STATE OF NORTH CAROLINA
DEPARTMENT OF TRANSPORTATION

Addendum No. 2

RE: Contract # C204812

NC-143 FROM 0.5 MI NORTH OF APPALACHIAN TRAIL TO NC-28 AND NC-28 FROM 0.2 MI WEST NC-143 TO 0.2 MI WEST OF SR-1228.

| REVISIONS |    |      |     |    |      | SHEET NO.<br>W32-2 |

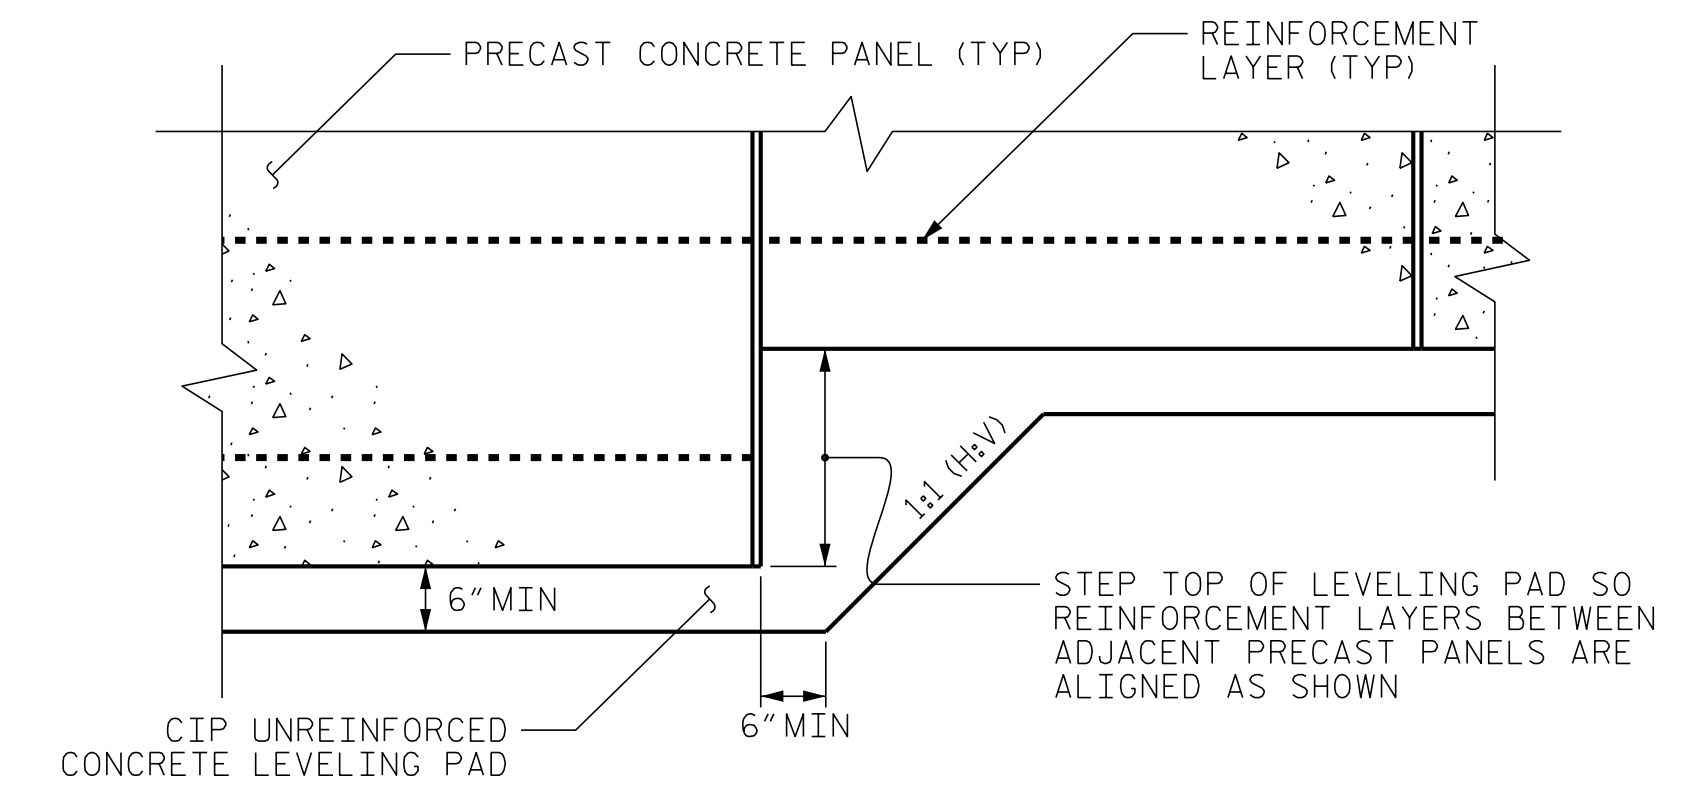
<u>Item</u>	<u>Description</u>	<u>Old Quantity</u>	<u>New Quantity</u>
0216-8802010000-E-SP	SOIL NAIL RETAINING WALLS	73,815 SF	60,345 SF
0217-8802015100-N-SP	SOIL NAIL VERIFICATION TESTS	34 EA	26 EA
0218-8802015110-N-SP	SOIL NAIL PROOF TESTS	188 EA	150 EA
